APPLICATION NO. 03DRB-02013	PROJECT NO. 1002517
PROJECT NAME Sandia Plaza Lots 23+24	
EPC APPLICATION NO.	
APPLICANT / AGENT AJ Ancheta	PHONE NO. 341-4757
ZONE ATLAS PAGE F-14	
(SDP for SUB), (SDP for BP), (FINAL PLATS), (MASTER DEV PLAN) (IR) (AA)	
<b>ONE STOP COMMENT FORM LOG</b>

D.R.B. CASE NO.: 1002517 DATE: 3/12/03 ITEM NO.: 19

**Subject:** Sandia Plaza Subdivision, Lots 23 & 24, Block 4/Sketch Plat

**PLAT OF  
 LOTS 23-A AND 24-A  
 BLOCK 4  
 SANDIA PLAZA SUBDIVISION**

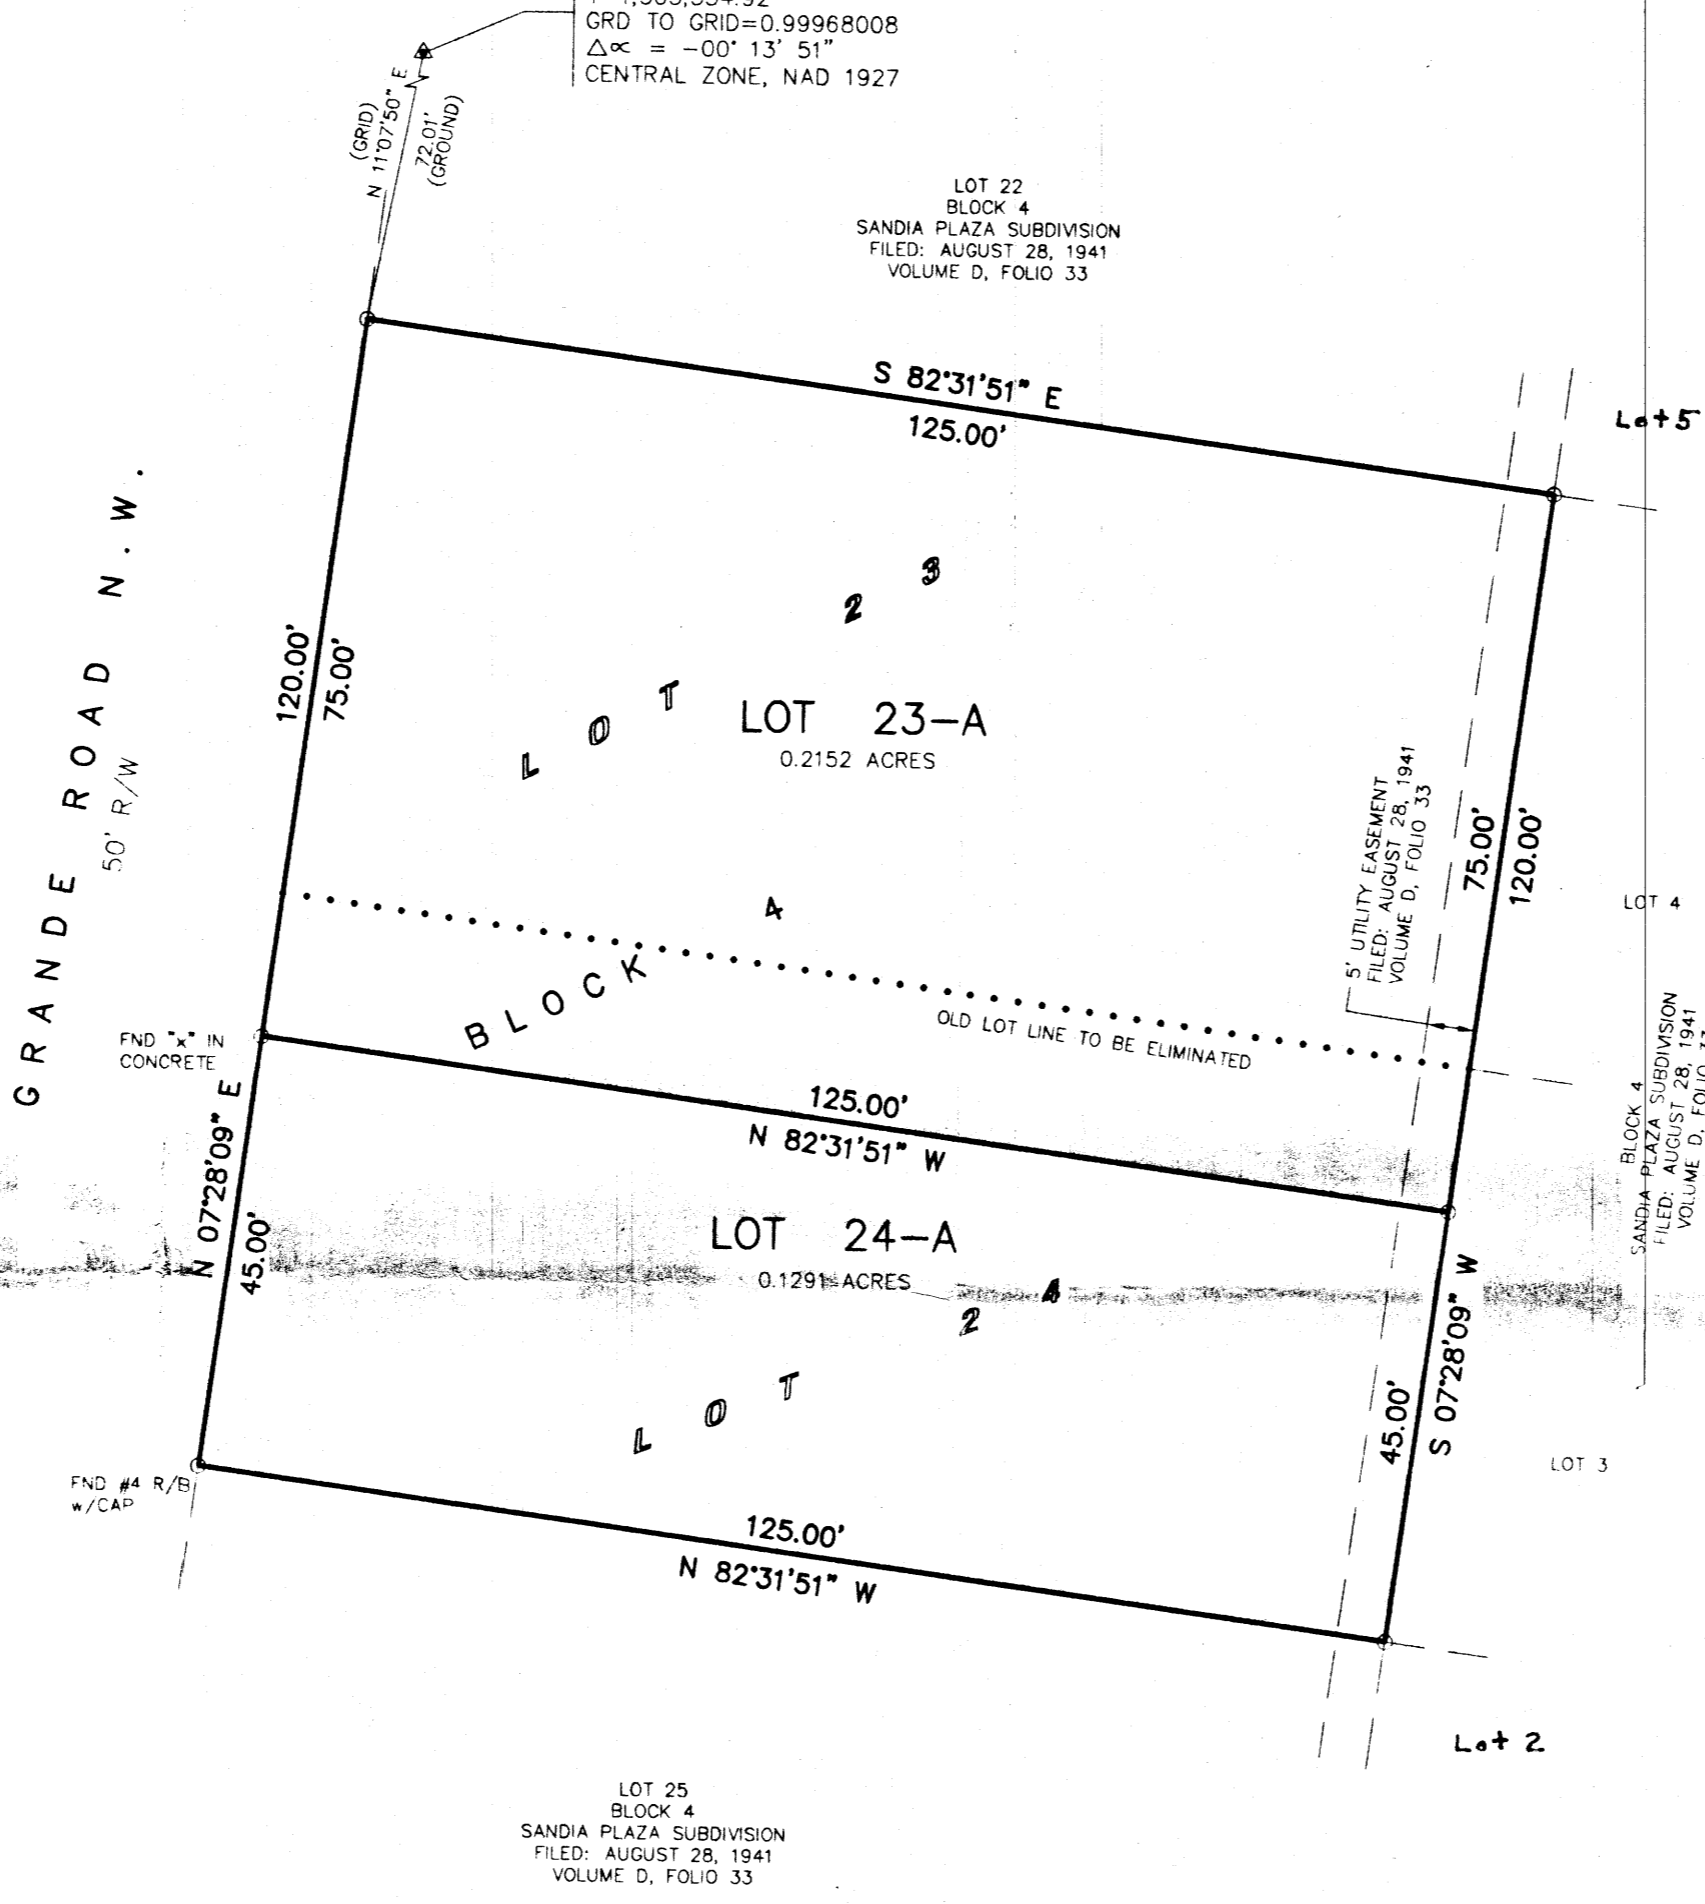
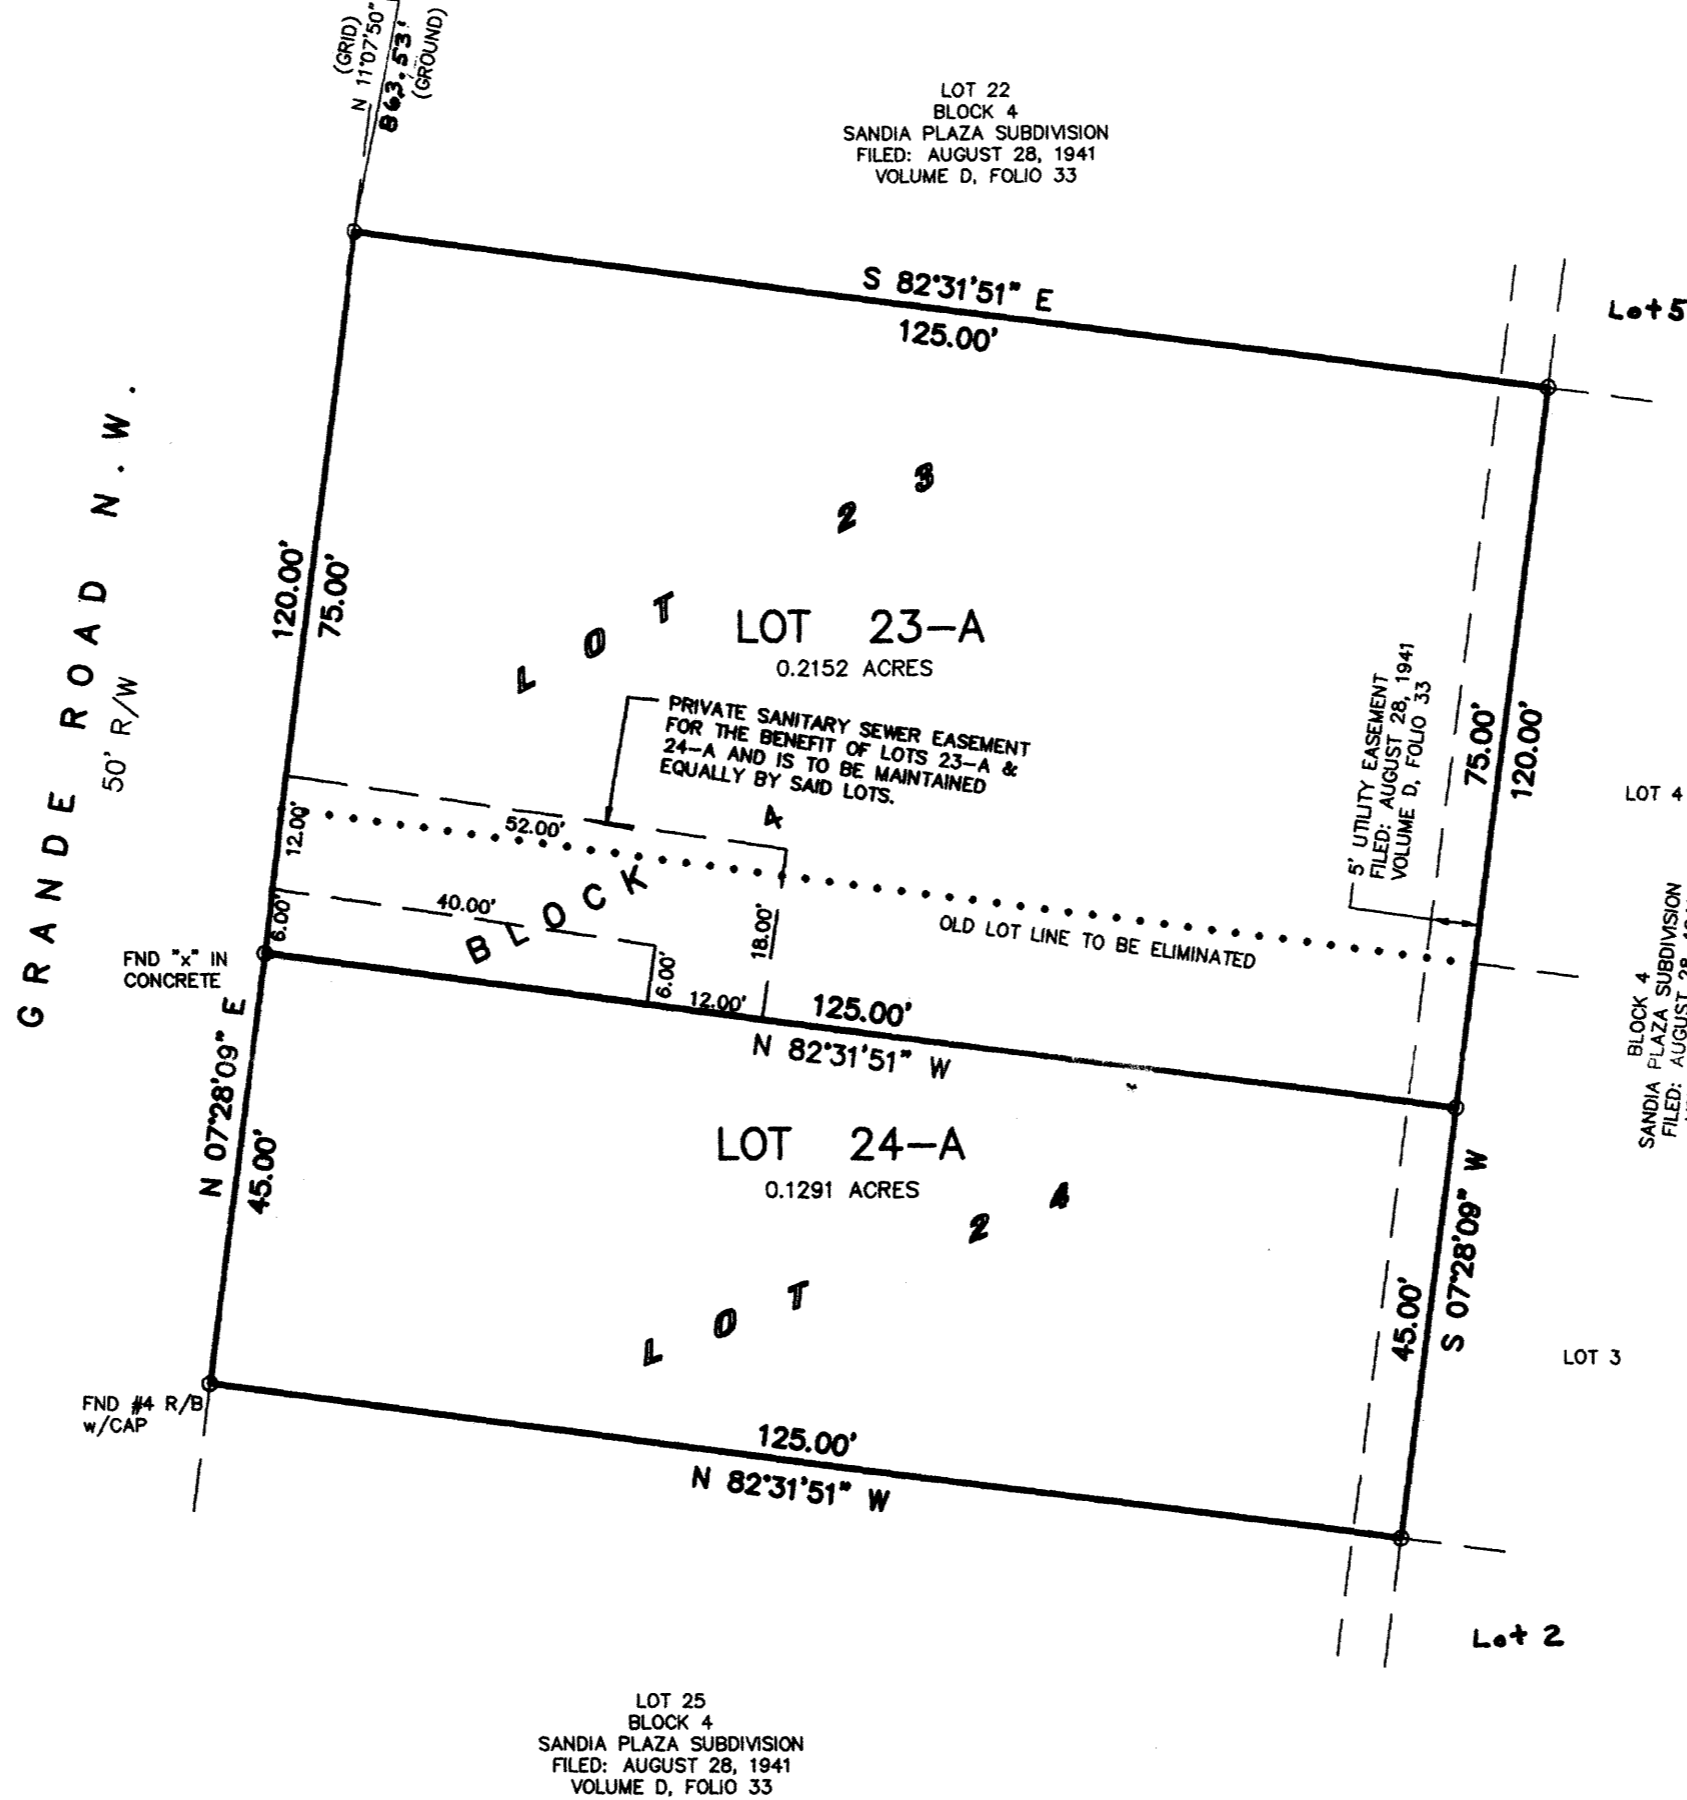
UTILITY DEV (505) 924-3989		
PLANS DISAPPROVED	DATE	DATE
PLANS APPROVED	DATE	DATE
	12/3/03	12/12/03
	12/18/03	
COMMENTS:		
Need copy of AS-Built Drawings for Sewer line in Grande to see if separate service is available for lot 24-A. See previous Stake Plat Comments. Still need additional language that sewer service line will be shared. add Note 11

①. New lot may have to share the existing sewer service line because main line in street is a 36" interceptor and we don't allow new service connections. Replat can contain language for a shared service.

The minimum lot width for R-1 zoning is <sup>50</sup>60 feet ~~and a minimum 6000 net square feet.~~  
The smaller lot is ~~only 5625 square feet & is less than 80~~ feet wide.
